URBAN DESIGN BRIEF

MARKETPLACE WEST

35 STOREY APARTMENT BUILDING
1034 MCGARRY TERRACE

Stantec has prepared the following response to recommendations received from the Urban Design Review Panel (UDRP) on 19 June 2023 following an informal presentation by the project team on 2 June 2023. Panel comments have been listed in the left column of the table below, whereas the project team’s response is provided in the right column.

1 WEST ELEVATION- WEST TOWER

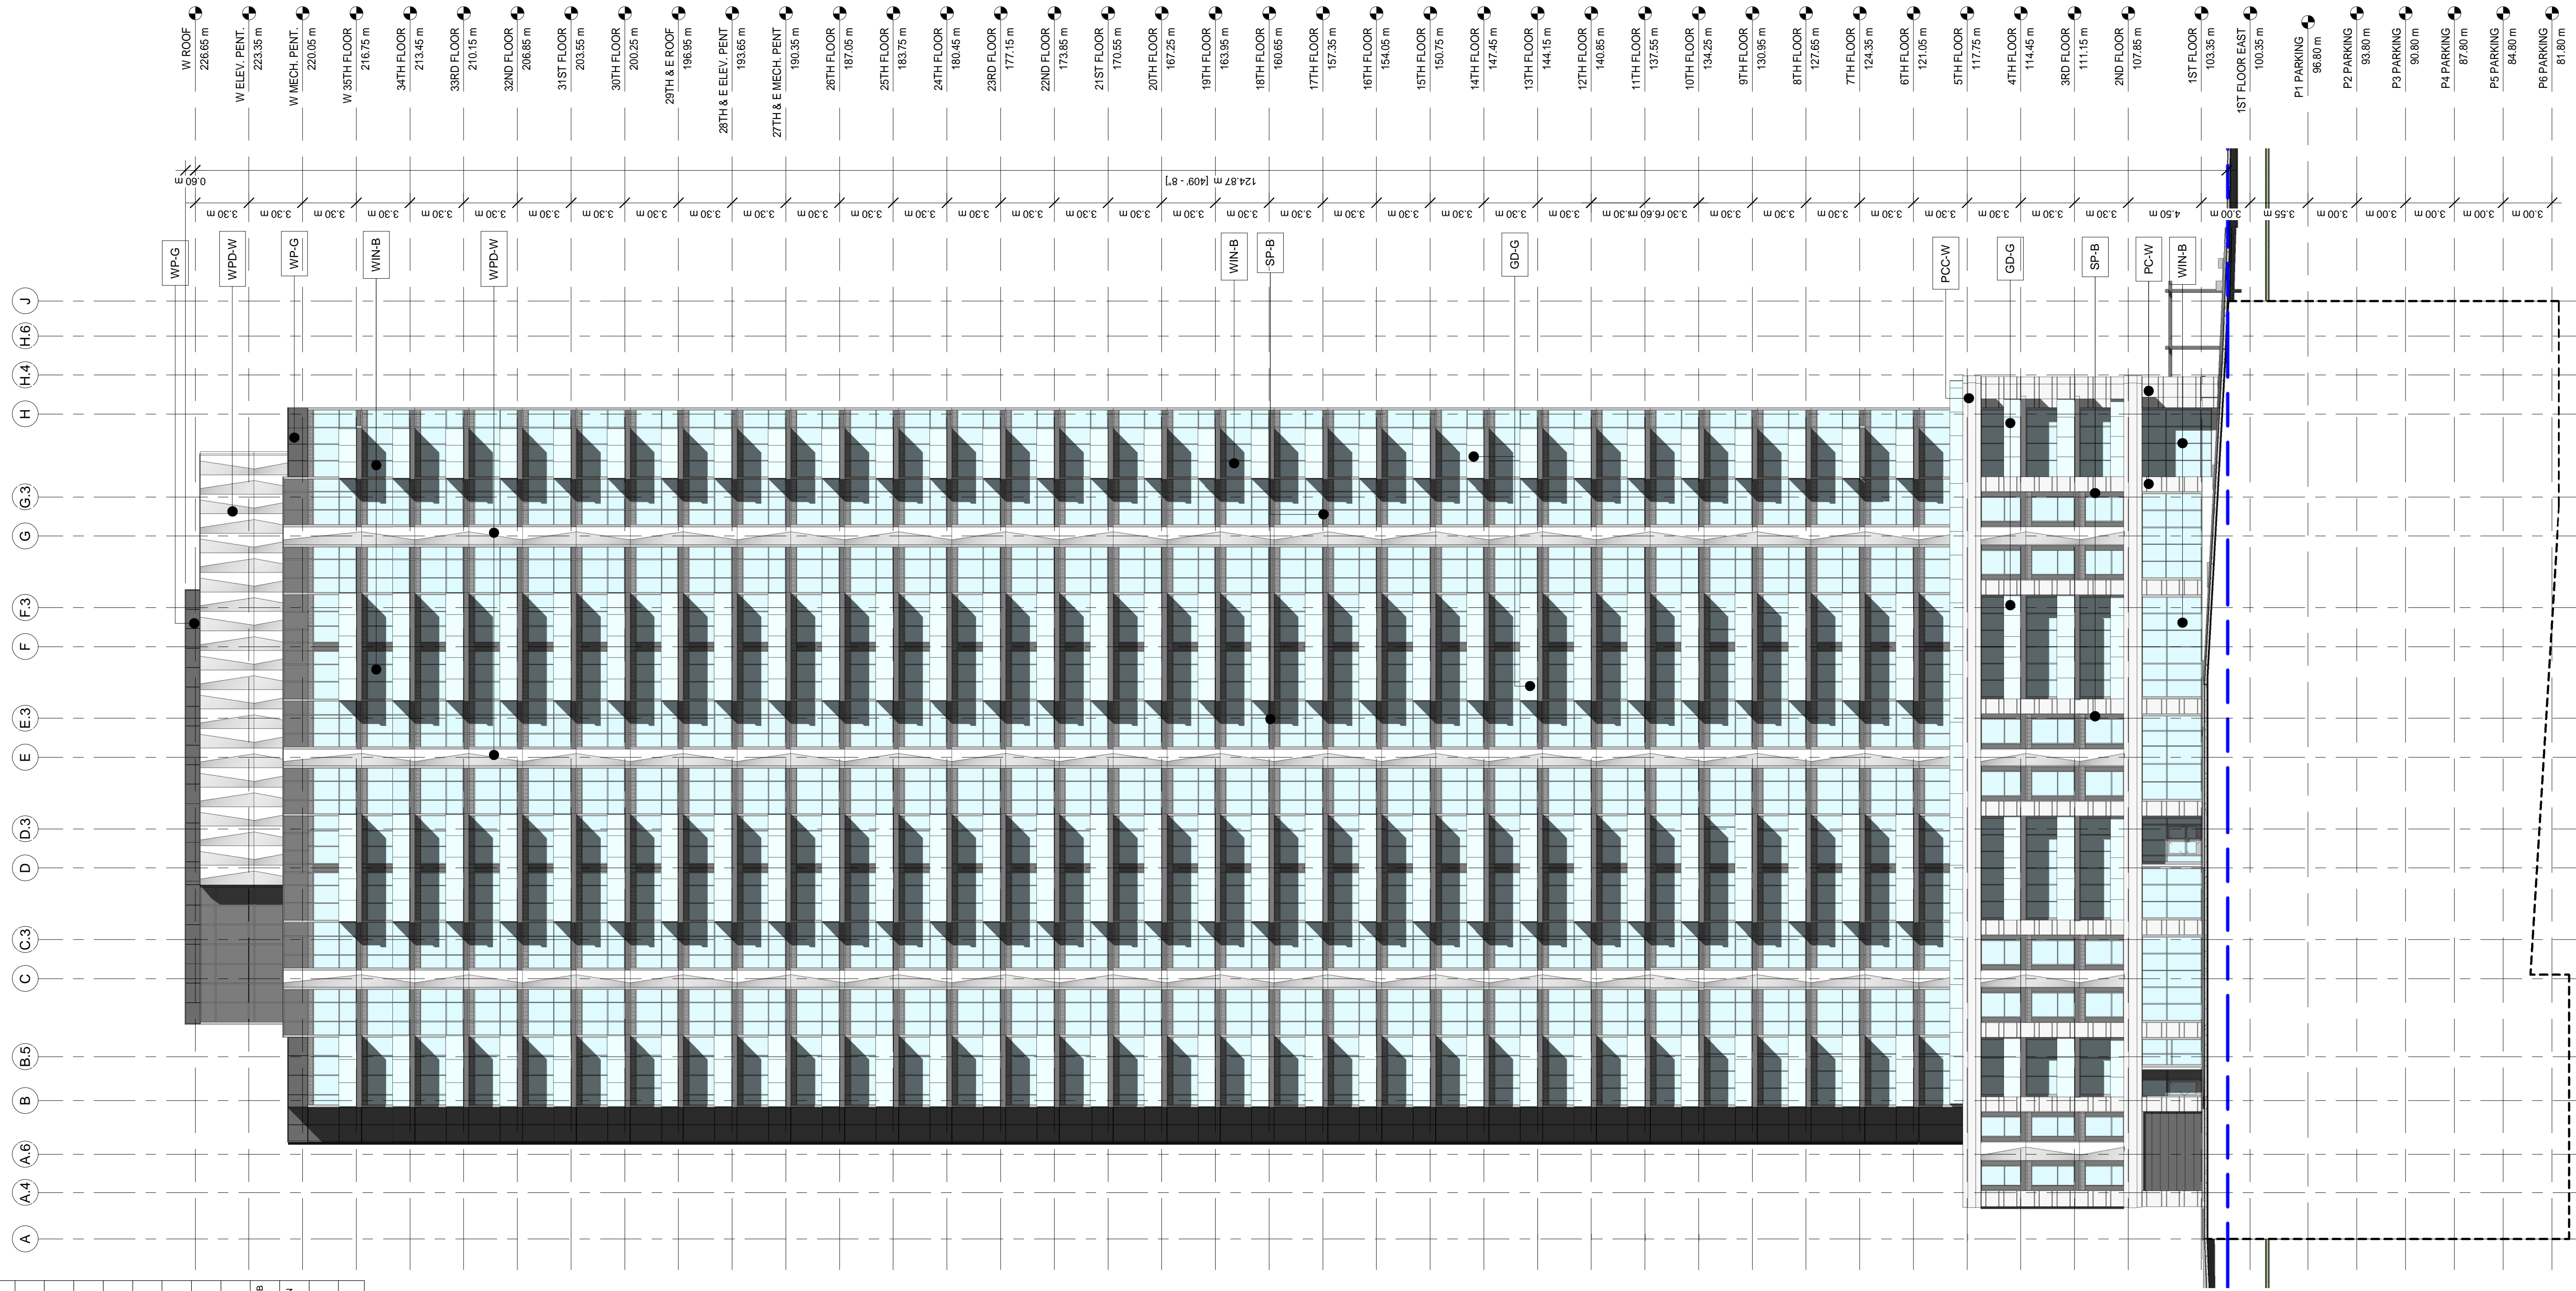
The Panel recommends stepping the towers back considerably along the street frontages

- Consider a minimum 3 metre step-back above the 4-storey podium
- Consider additional step-backs up the tower.

The Panel recommends staggering the heights of the towers to a more appropriate scale and transition from the surrounding context.

- Consider a 30-storey tower on the west side nearest to McGarry Terrace, and a shorter tower closer to 20-storeys on the east side

Step-backs have been provided from Marketplace Avenue and McGarry Terrace. Tower floorplates have been reduced to the extent feasible to increase tower separation distances and increase step-backs.

To ensure that there is variation in height between the two towers, it is proposed that the west tower be reduced to 35 storeys in height, whereas the east tower would be reduced to 26 storeys.
